Road Safety Audit Stage 2

Hatfield Galleria – Revised road layout

19 January 2016

Client Name: Land Securities Group PLC
Document Reference: WIE17416_SA001_A01
Project Number: WIE17416

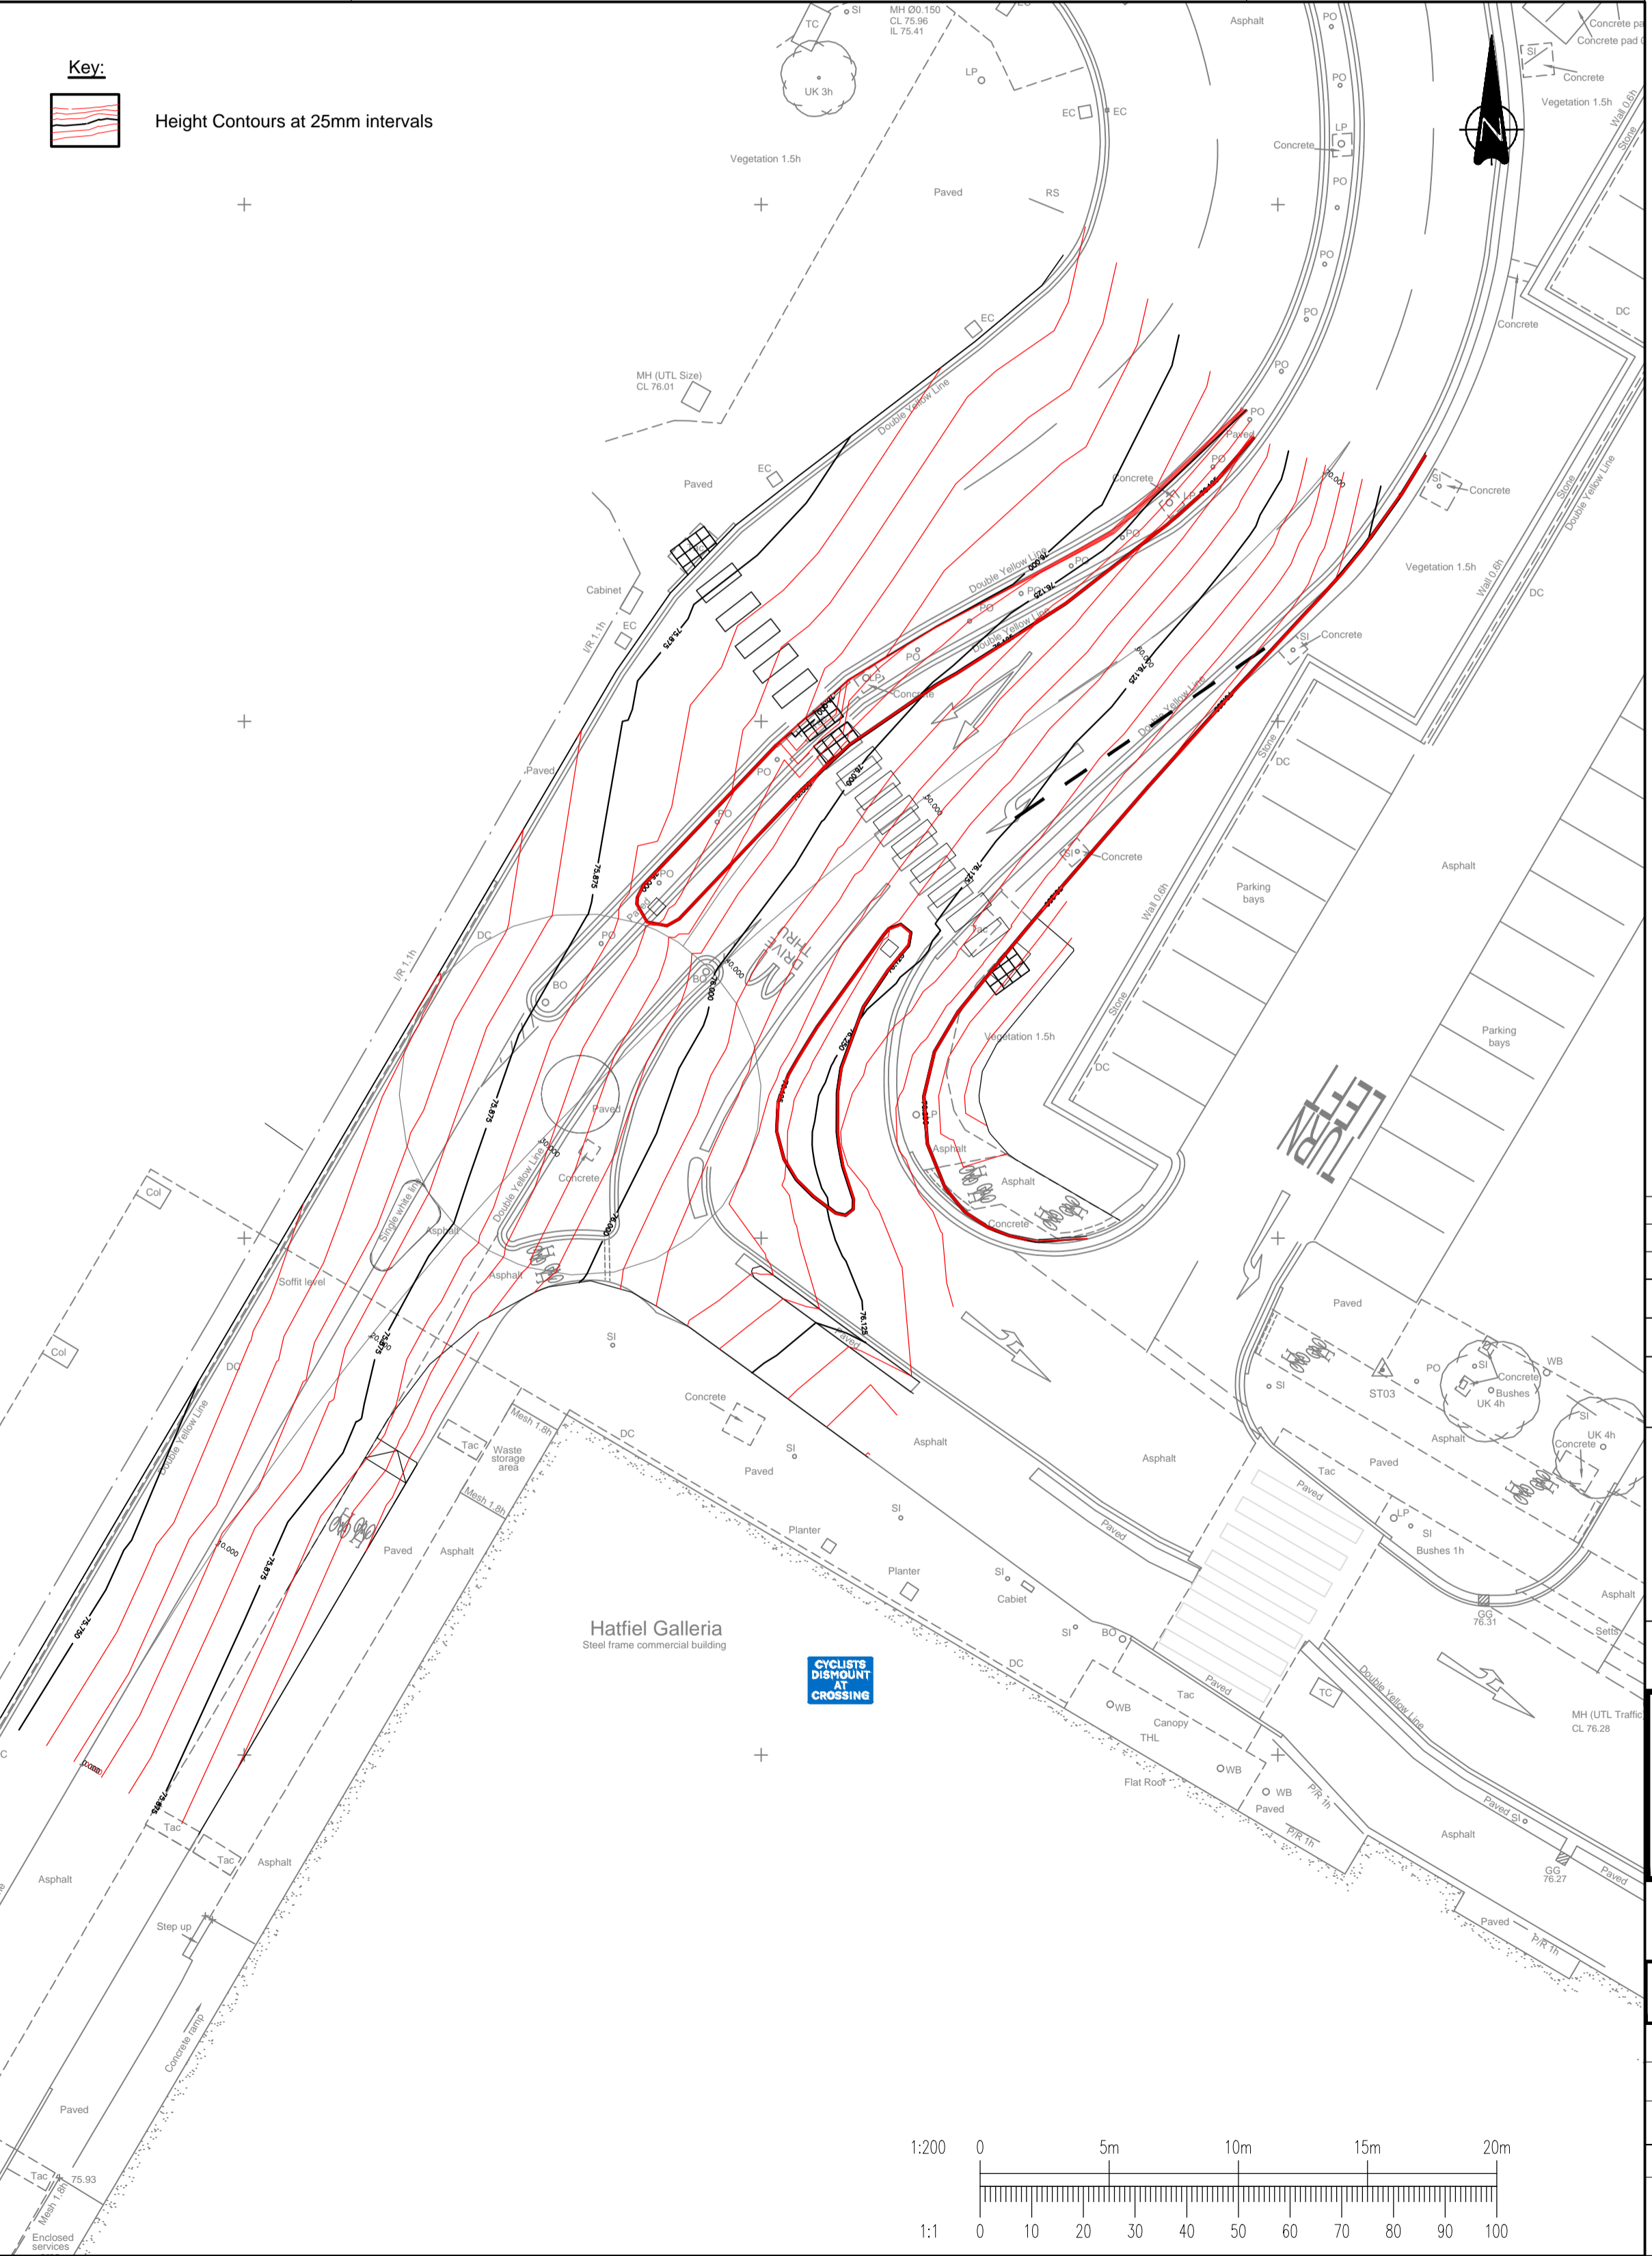
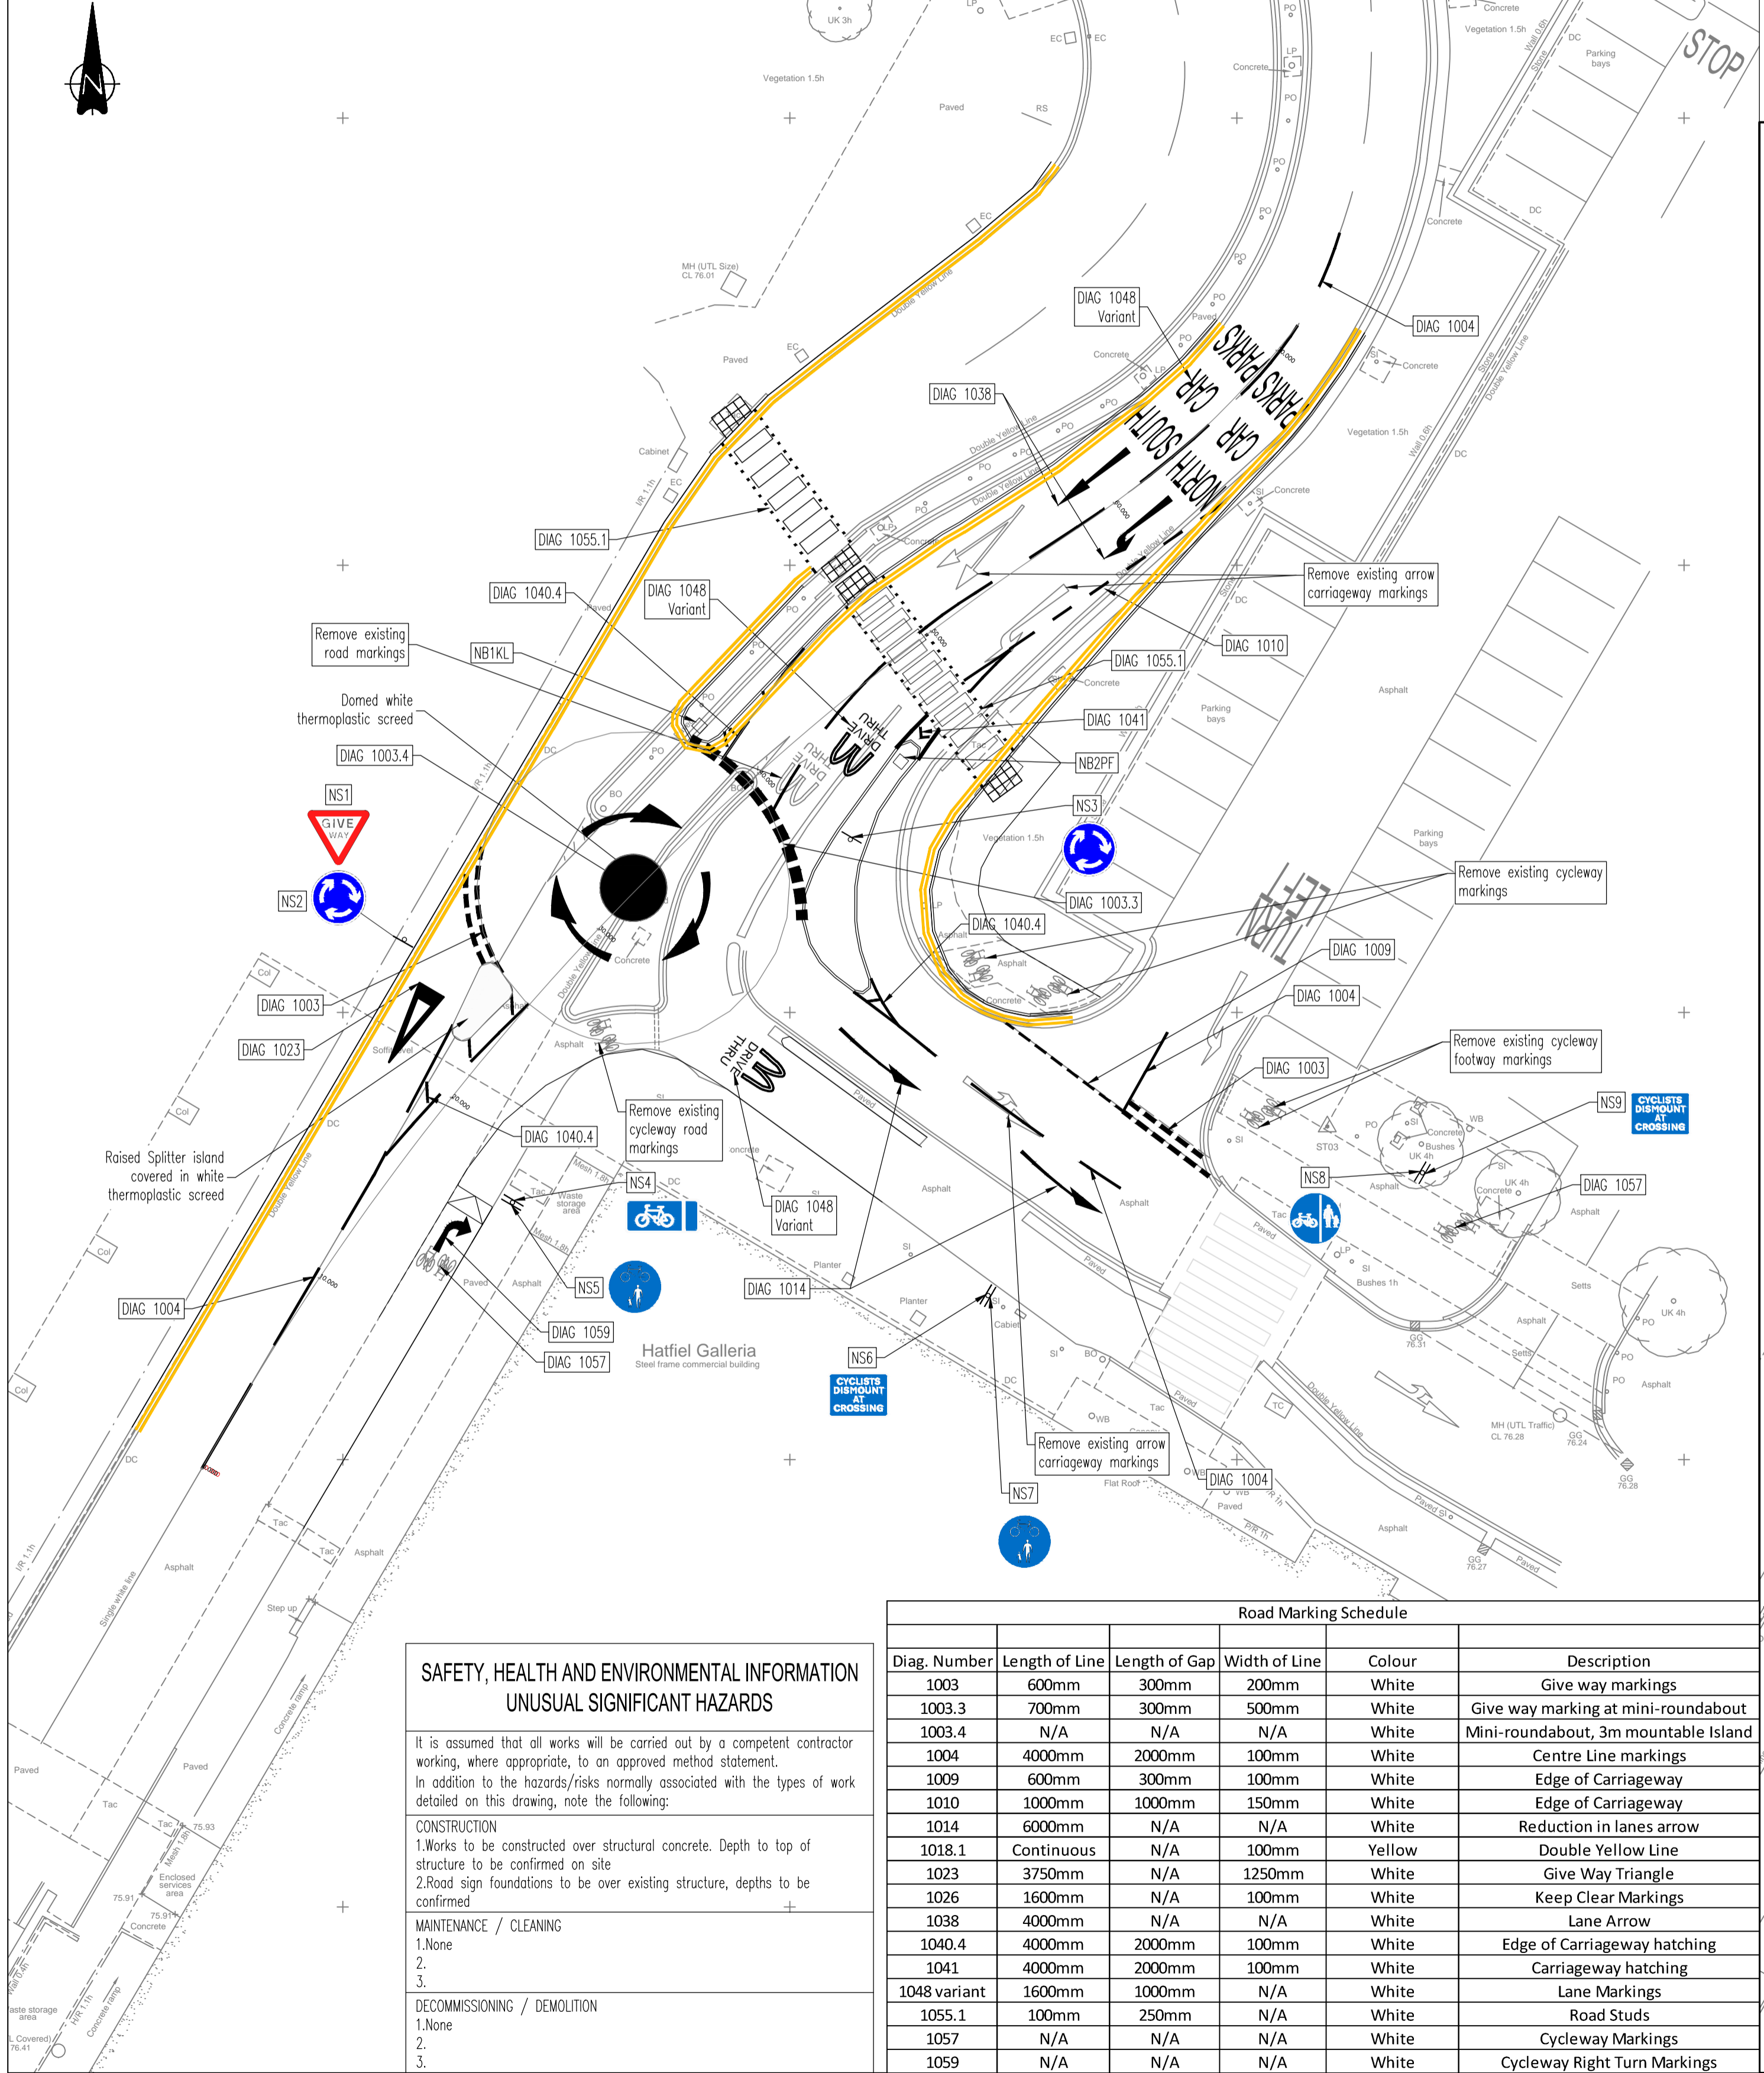
- 3.1. The drawing provided showing vehicle tracking of a large car movements at the proposed mini roundabout highlights a southbound vehicle going straight over at the roundabout colliding with a southbound vehicle turning left into the McDonalds drive through lane. This could result in occupant injury of a driver or passenger in either vehicle.

- 3.3. The scheme proposes a combined footway cycleway on the existing southern footway alongside the McDonalds drive through. This footway is currently fairly crowded and the width is restricted with planters and street furniture associated with the drive through. Introducing a combined footway/cycleway at this location would leave pedestrians and cyclists vulnerable of collision resulting in injury.
- 3.4. In addition to this, a 'cyclist dismount' sign is proposed at the eastern end of the southern footway/cycleway and it is unclear where cyclist are meant to continue from this point.

- 3.2. The design should be revised to safely accommodate all movements at the proposed mini roundabout without vehicles colliding.

- 3.5. The Design Team should reconsider the provision of a combined footway/cycleway at this location whilst ensuring there is a continuous route provided for cyclists throughout the scheme.
